**From:** [REDACTED] <[REDACTED]@sillslegal.co.uk>  
**Sent:** 07 May 2021 14:13  
**To:** Little Crow Solar Park  
**Subject:** RE: Little Crow Solar Park - Deadline 1 Submission  
**Attachments:** Little Crow Solar Park - Deadline 1 Submission

#### **Little Crow Solar Farm**

We now refer to those questions posed to the Interested Parties in the ExQ1:

Appendix B 2D Plan View of Noise Propagation for Work No. 2A Layout (Without Mitigation)

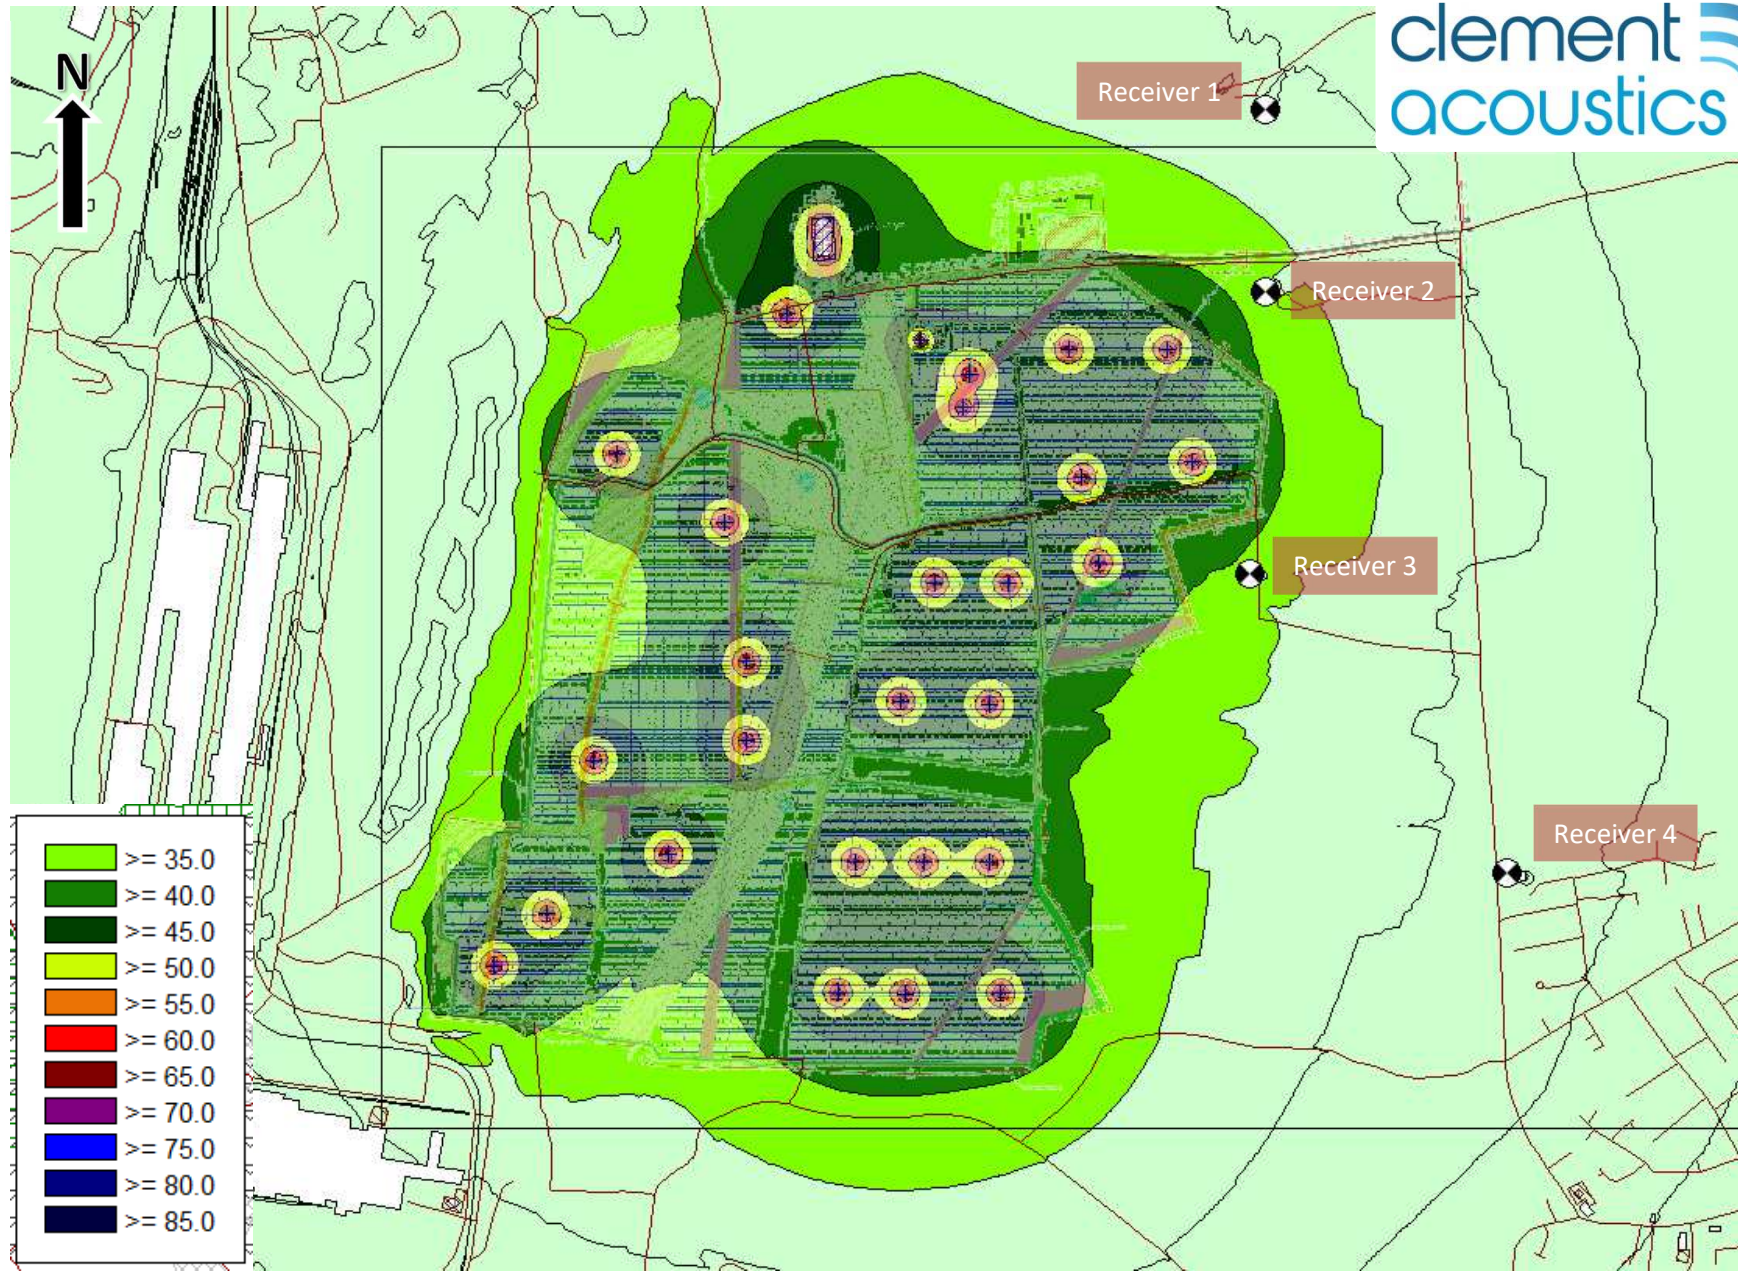
We consider the extent of the Order Limits referred to in the Noise Impact Assessment (APP-085) are erroneous. That feeds through into the narrative of the Noise Impact Assessment. The roadway and a section of land above the roadway (immediately south of Plot Wood) are included within the Order Limits as can be seen from the site plan in APP-006. However, these areas are not included in Figure 14027-SP1 purportedly describing the Order Limits for the purposes of the Noise Impact Assessment.

The effect of this is that Heron Lodge is described as north-east of the source of noise (Para 2.0 Noise Impact Assessment). Clearly Heron Lodge is north-east of the Solar Farm, but it is not north-east of the nearest source of noise, which is the roadway. Heron Lodge is due south of the nearest source of noise (the roadway) and potentially is also closer to the land above the roadway omitted from Figure 14027-SP1, than it is to where the main body of the Solar Farm is to be located. It is not clear what noise will be generated in this area to the north of the roadway.
